City of Albuquerque

RE: DRAINAGE PLAN FOR YELLOW FRONT (M-12/D3)
(BP87-718) RECEIVED AUGUST 12, 1987

RE: DRAINAGE PLAN FOR SHOPPING CENTER ADDITION - GOFF BLVD. &
ARENAL ROAD, SW (M-12/D3) (B-87-718) RECEIVED JULY 30, 1987

C-2

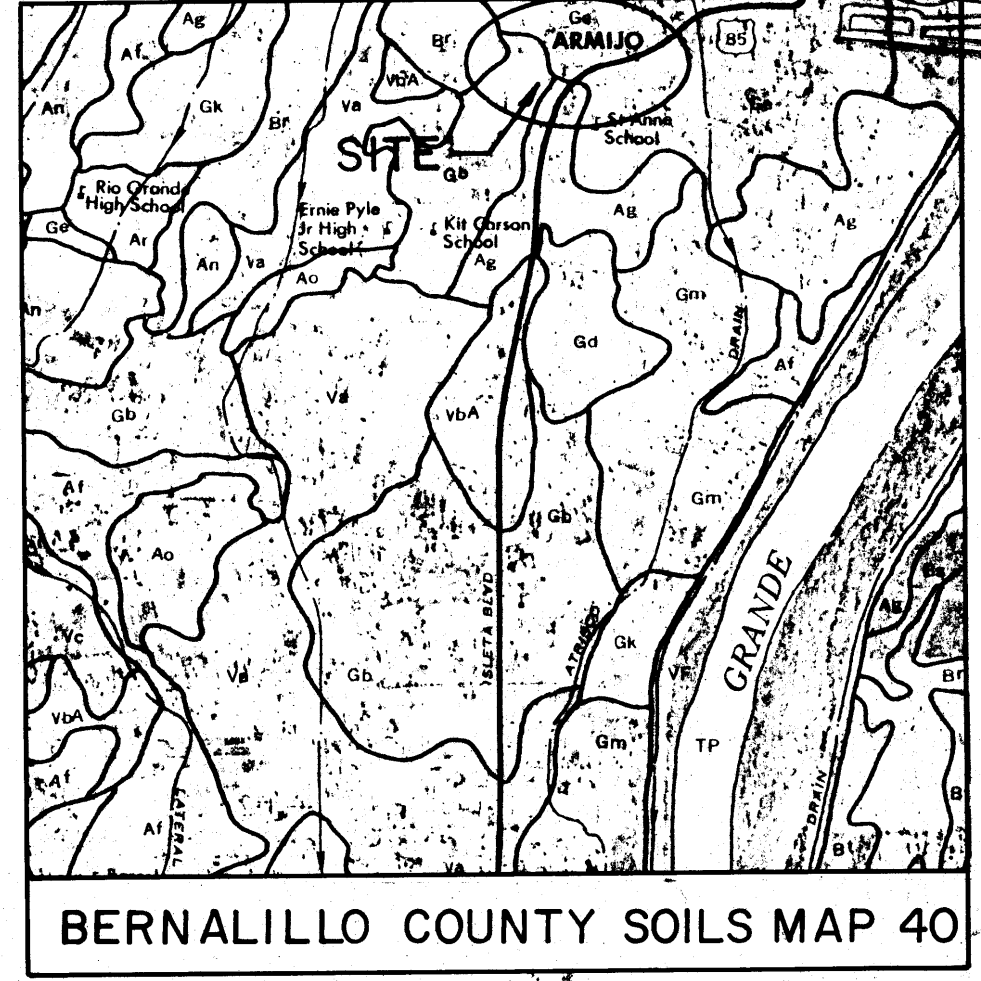
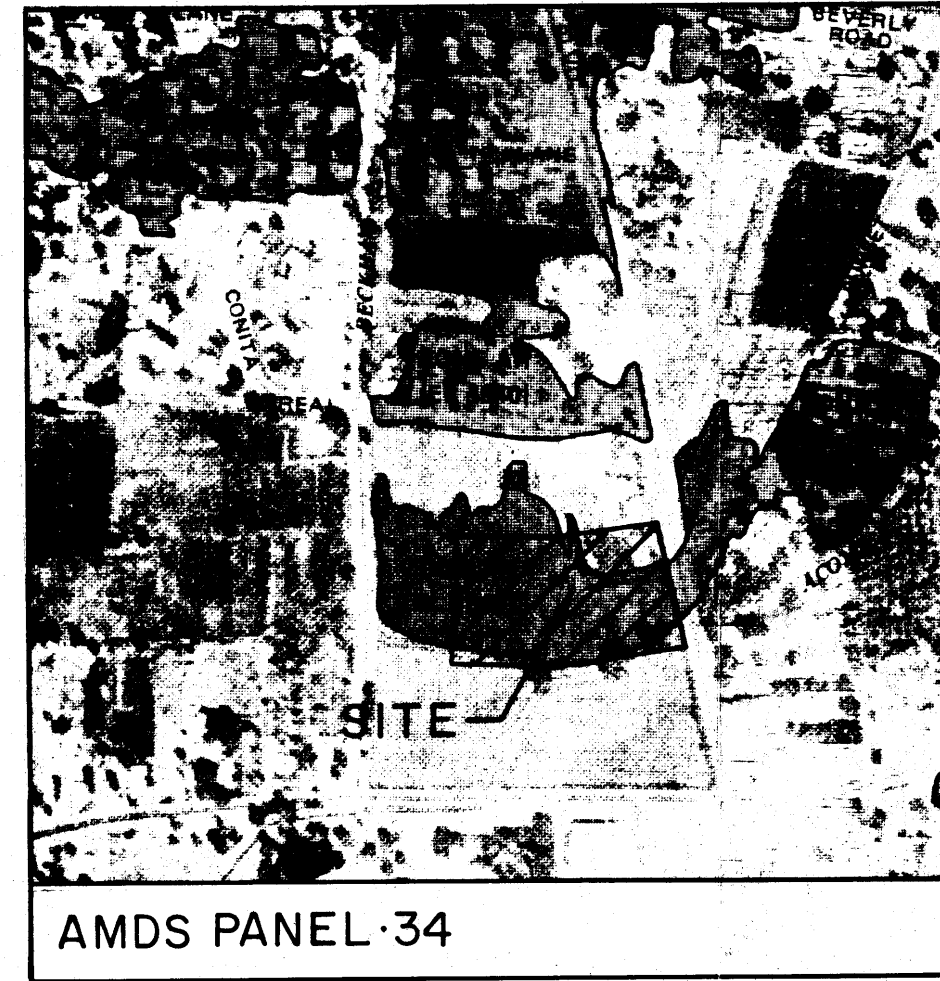
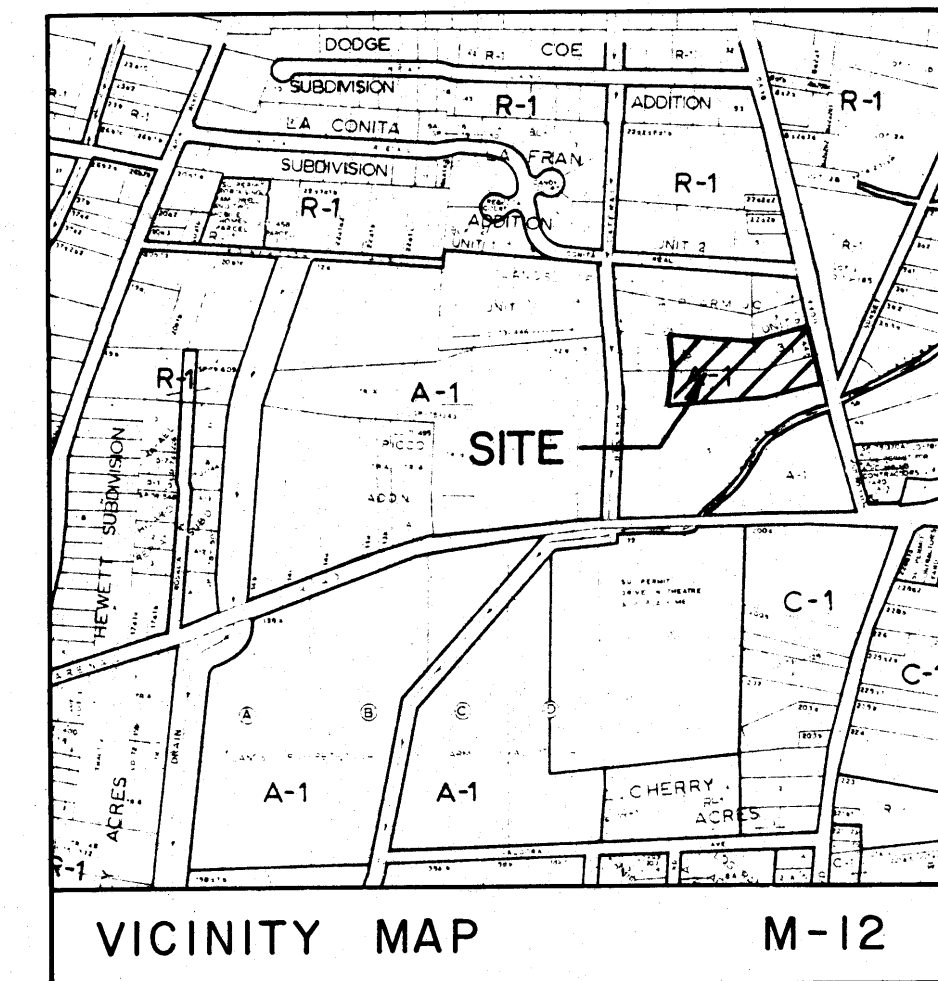
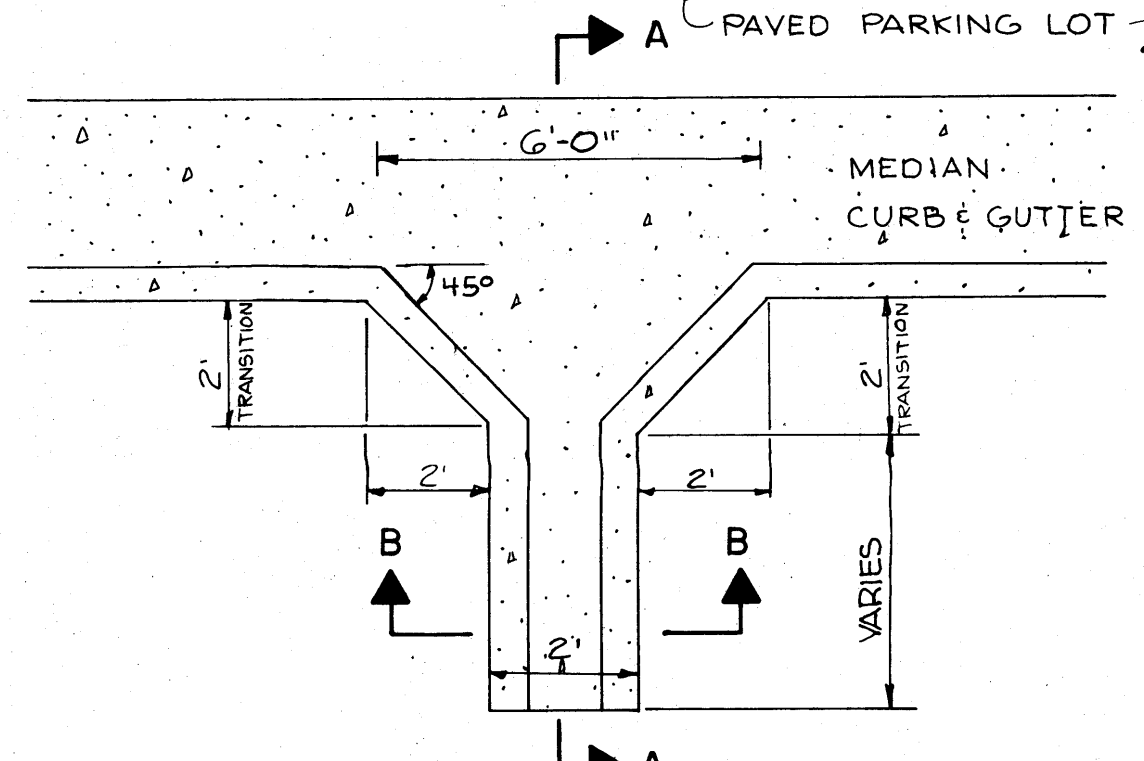
1. The proposed retention pond needs to contain 100% of the total developed runoff.
2. Please coordinate your efforts with the County Road Department.
3. Need a private drainage easement from the south property owner to pond on their property.

1. The proposed retention ponds will need to contain the displaced flood volume and the difference between the site's developed and undeveloped runoff volume.
2. Please coordinate your efforts with the County Road Department.
3. Need a private drainage easement from the south property owner to pond in their property.

As per our conversation the ponds
have been enlarged to accommodate 100%
of the 100 year storm.
